**City of Portland, Maine - Building or Use Permit Application**  
 389 Congress Street, 04101 Tel: (207) 874-8703, Fax: (207) 874-8716

Proposed Project Description:  
 Build New 71' x 40' Single Family w/ 24' x 22' Attached Garage  
*NO rear deck*

Application ID Number: 2-0814

Application ID Number: 2-0655

RIGHT SIDE ELEVATION

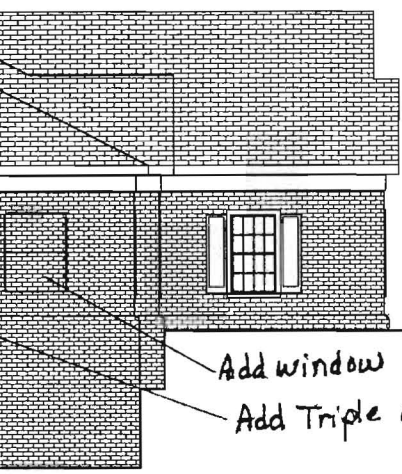
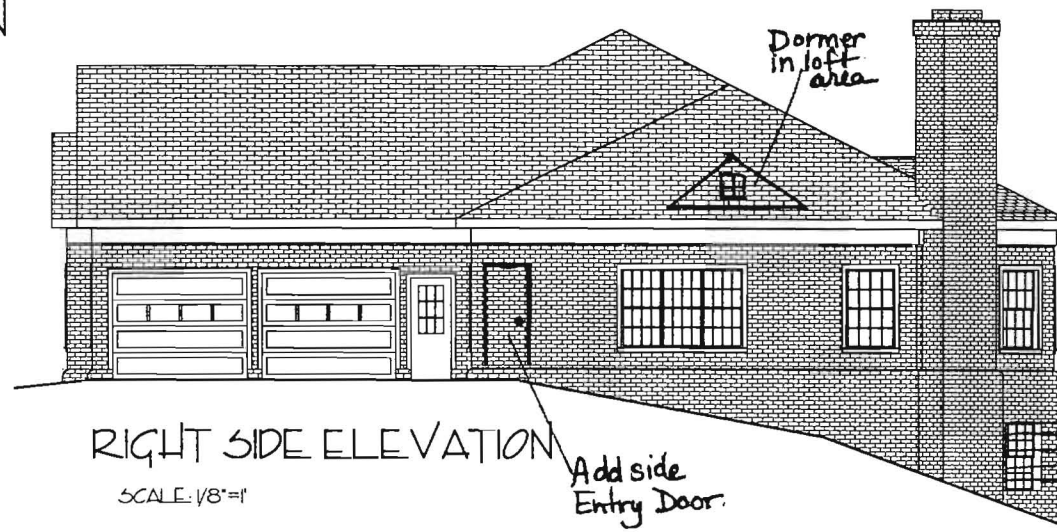
It is understood that there will be no daylight basement and that less than half of the basement floor-to-ceiling height will be above grade. It is also understood that the rear deck will not be a built structure. It is also understood that the right hand side bulkhead will not be constructed.

PLAN SHOWING A
PROPOSED BUILDING LOCATION
MADE FOR
ROBERT P. BURKHARDT
OF LAND LOCATED AT
HASKELL STREET, PORTLAND, MAINE
SCALE: 1 INCH = 30 FEET, JUNE 1, 2002
COMPILED BY:
WILLIAM G. AUSTIN, PLS 2174
82 ELDERBERRY LANE
NEW GLOUCESTER, MAINE 04260
(207) 632-2959

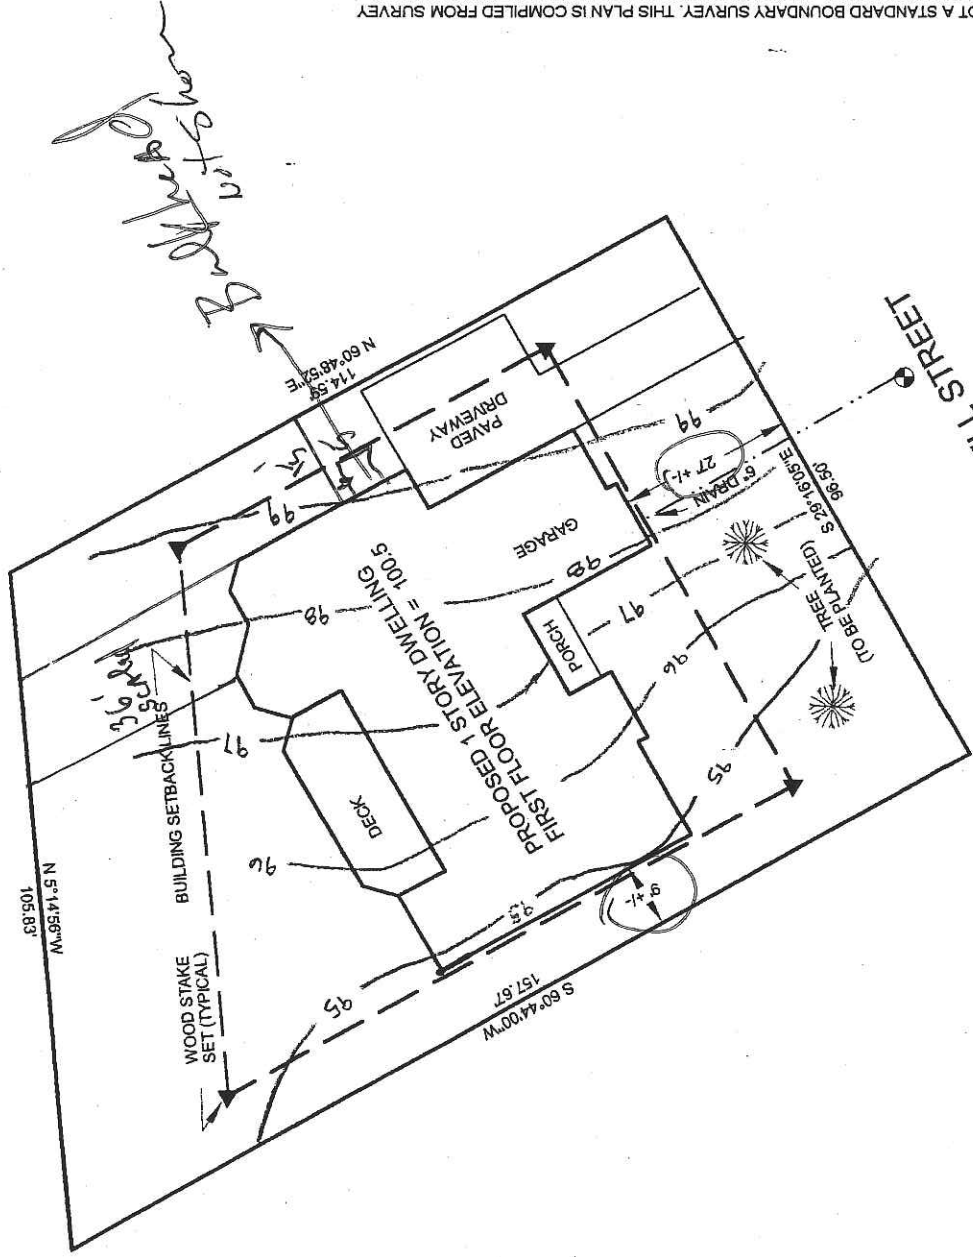
Confusing permit with two different plot plans attached. - I finally determined the correct one - too close to lot lines and at least 100 sq. Ft. Over lot coverage requirements. - I put a call into the owner. - owner came in - the grade level has

This permit is being approved on the basis of plans submitted. These plans were changed by the owner while at the City counter in order to correct some zoning deficiencies. Any deviations shall require a separate approval before starting that work.
